**Notice of Permit Denial**

COUNTY: Harnett  
NAME: Kicking Camel Grill  
STREET: 174 N. McKinley St.  
CITY: Coats DATE: 6/23/22  
STATE: NC ZIP CODE: 27521 TIME: 10 am

Re: Kicking Camel Permit Denial on 6-23-22

PLAN

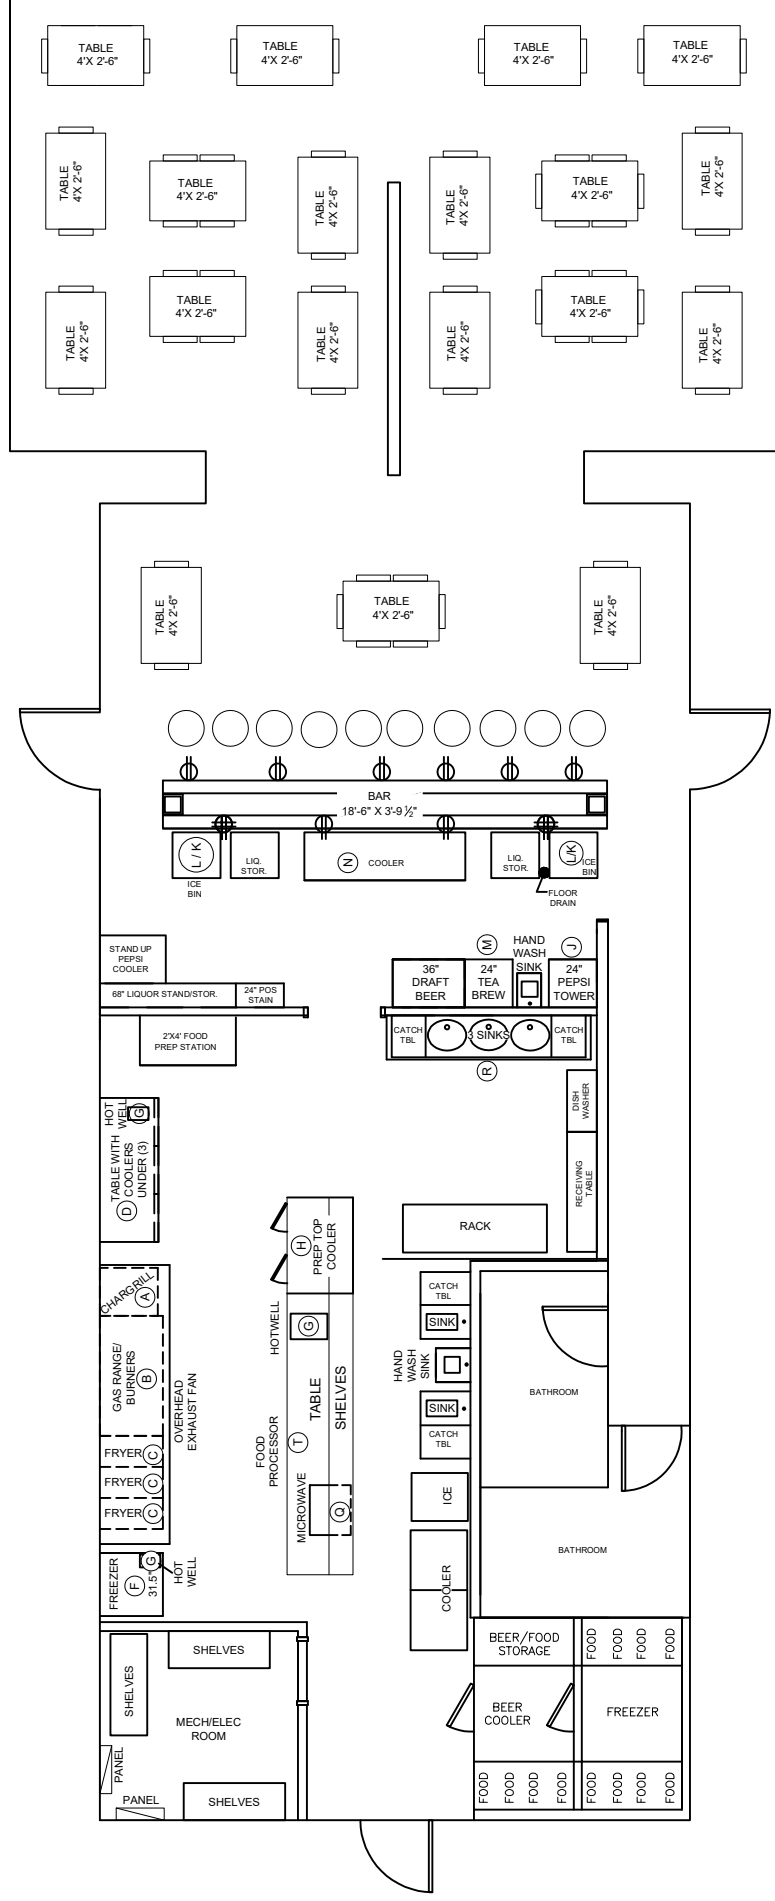
- 1- Equipment was not in place and operational. Equipment not in place per site plan.
- 2- Floor was not smooth and sealed. Flooring shall be smooth, no holes or crevices and sealed.

15- Food processor must be NSF/ANSI approved. Hot wells placed as per site plan. Discussed moving hot well to prep table due to breaching on work top freezer.
